**Transport
for NSW**

**Mixed use development at Site 53, Sydney Olympic Park (SSD 7033)
Notice of Exhibition**

CD15/18831

- traffic controller ahead symbolic day T1-200-1*
- prepare to stop T1-18
- workers ahead symbolic day T1-5-2 *
- Work Zone
- Class B Hoarding
- traffic controller

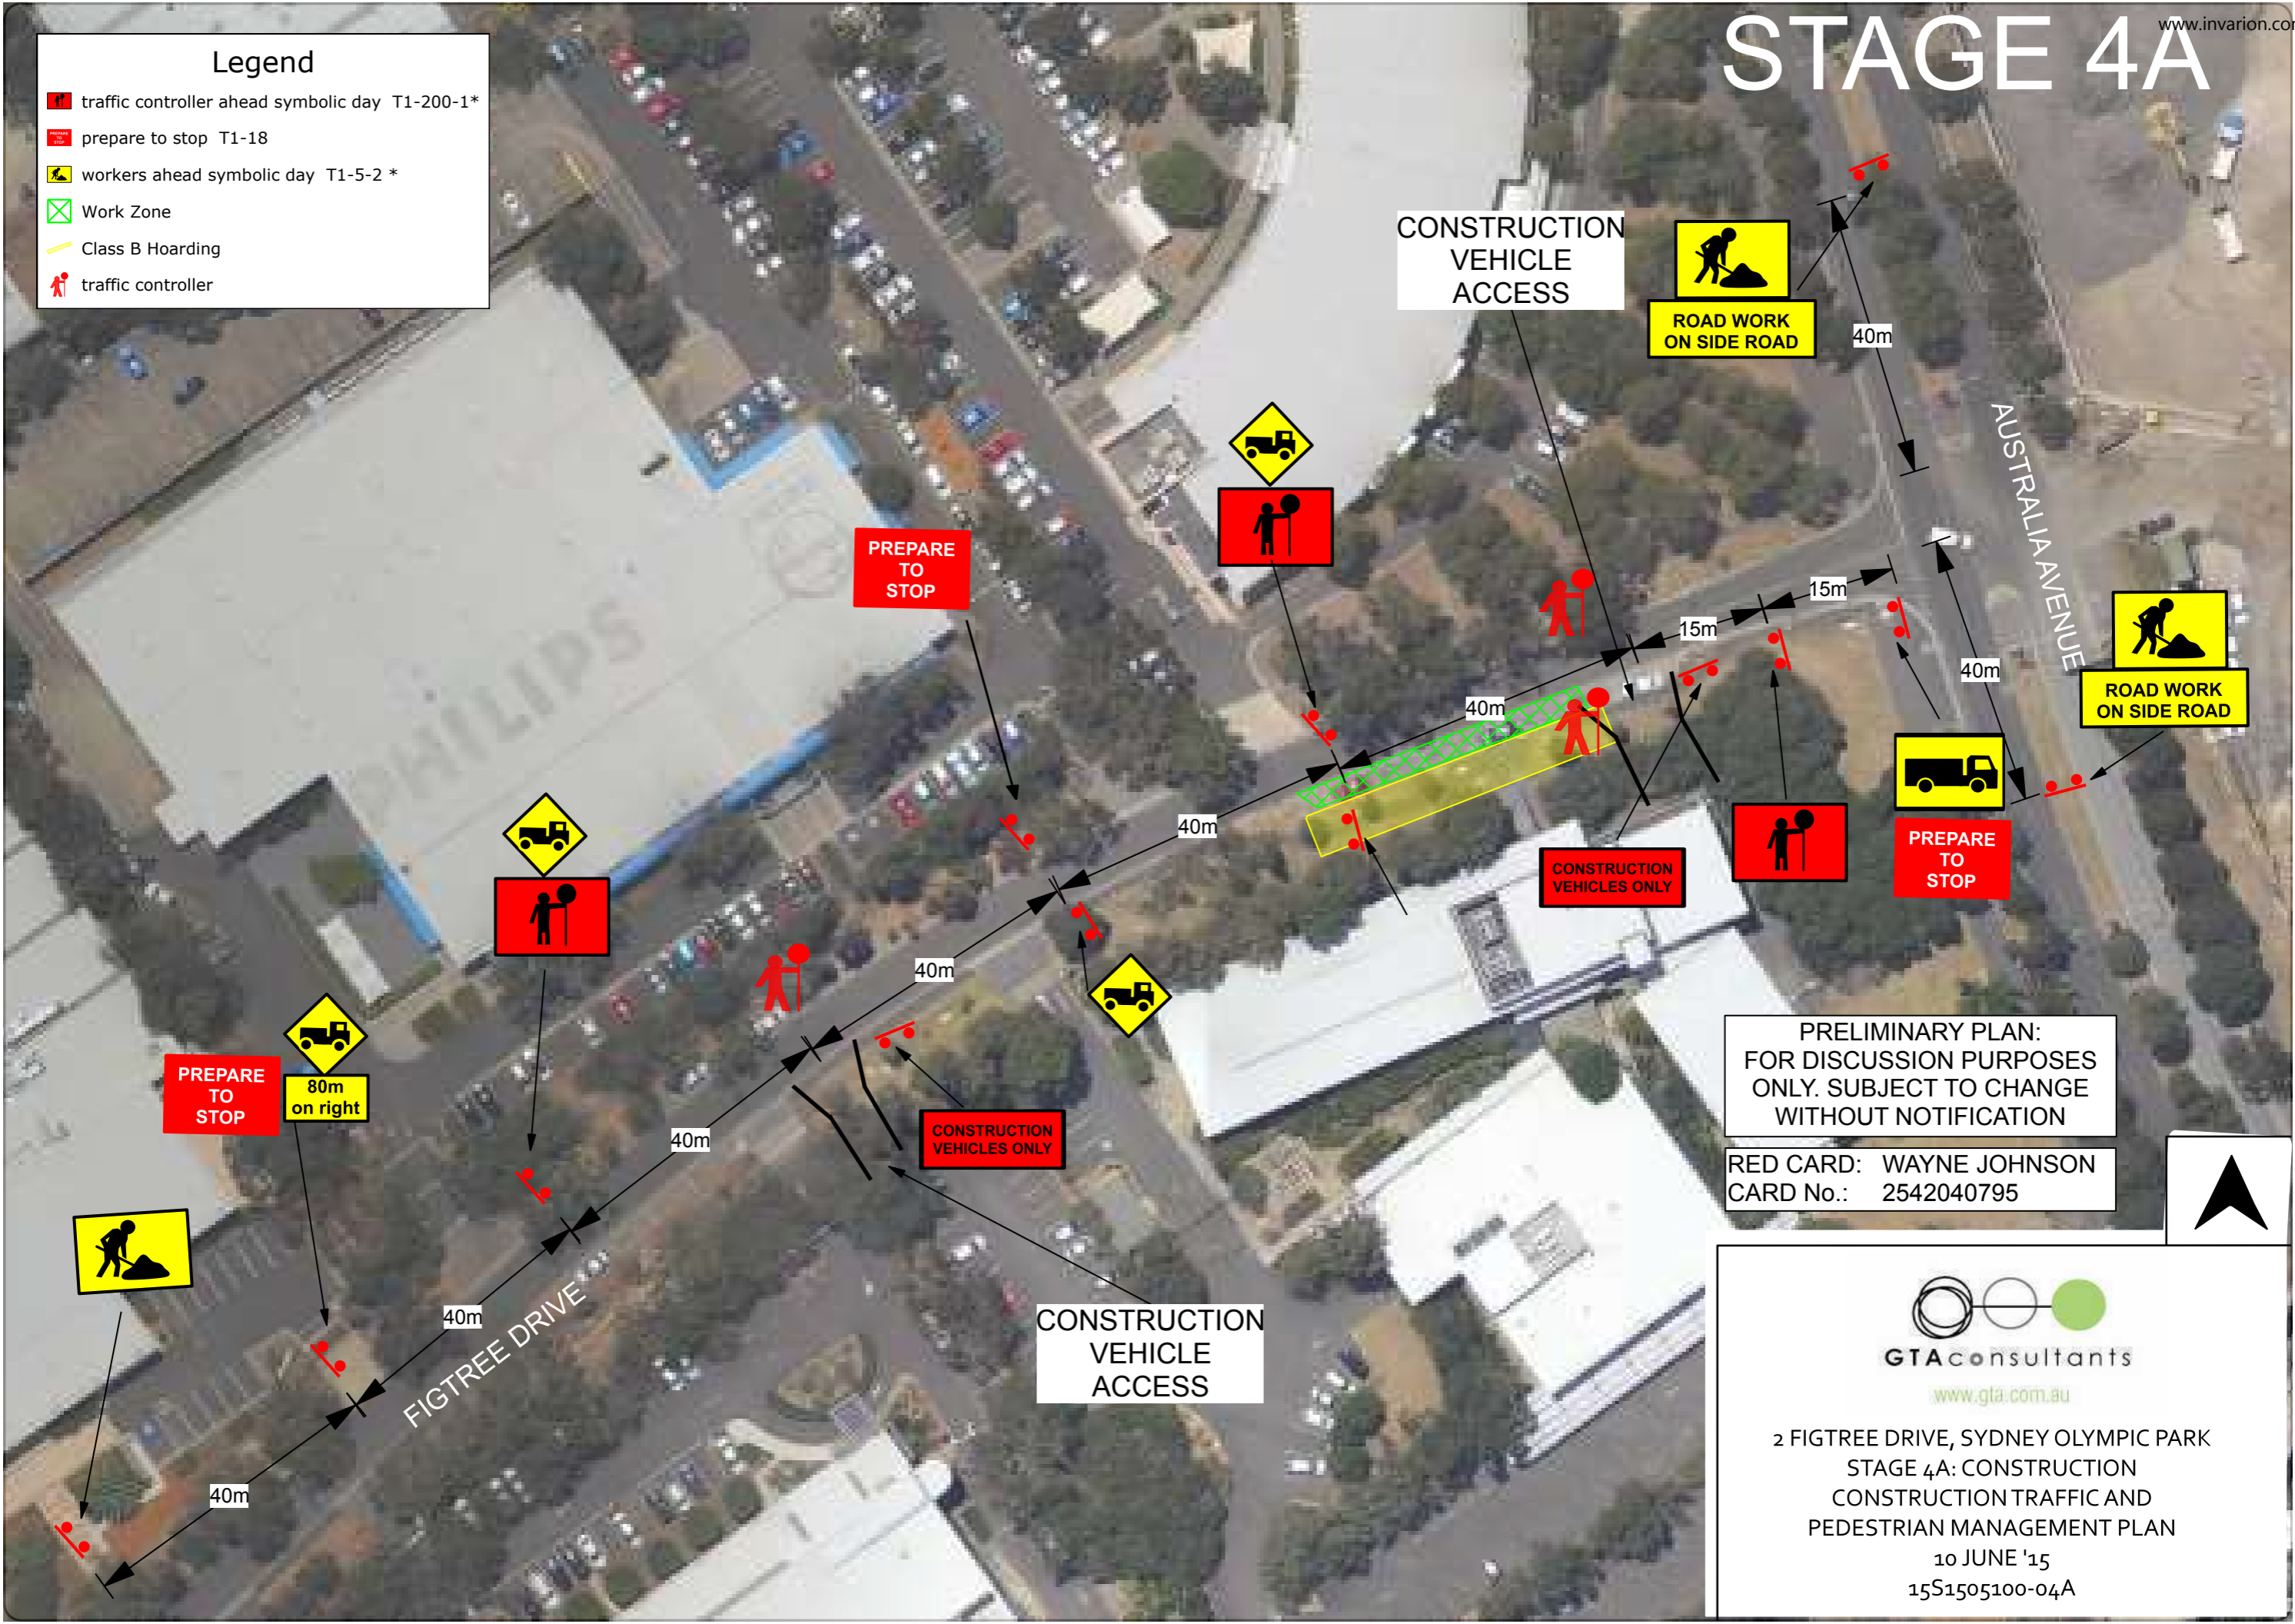
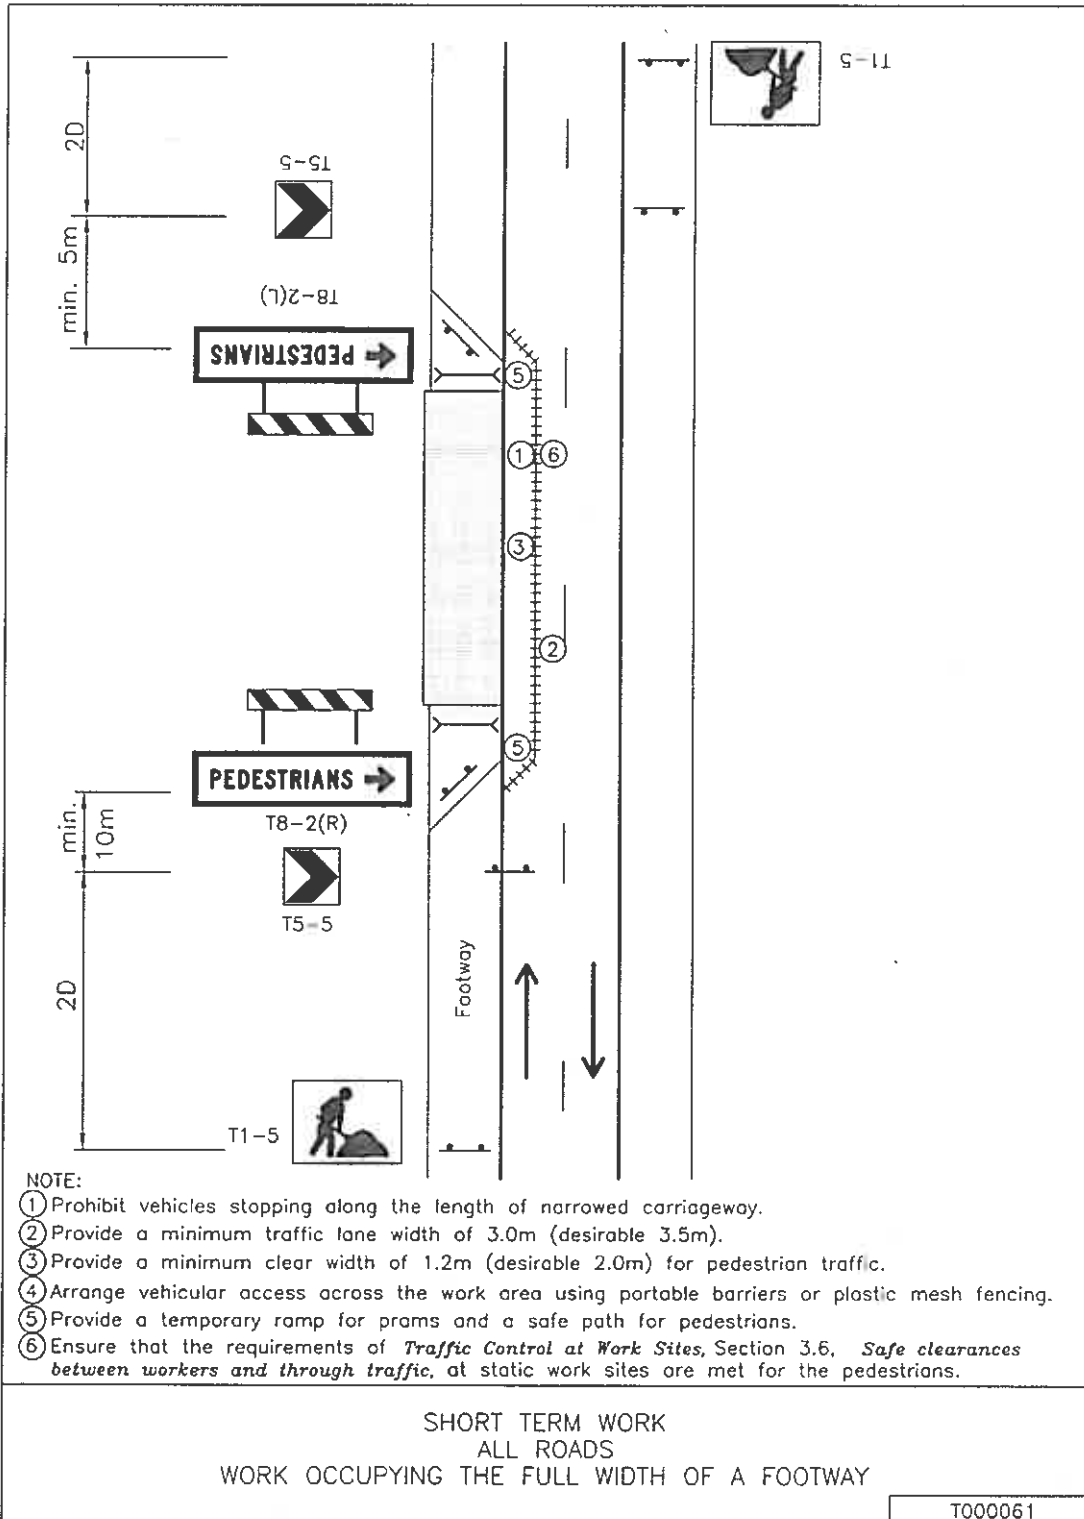
TfNSW requests that a Construction Traffic Management Plan (CTMP) be prepared in consultation with TfNSW prior to the commencement of construction. The CTMP needs to specify any potential impacts to general traffic, cyclists, pedestrians and bus services within the vicinity of the site from construction vehicles during the construction of the proposed works. Should any impacts be identified, the duration of the impacts and measures proposed to mitigate these should be clearly identified and included in the CTMP.
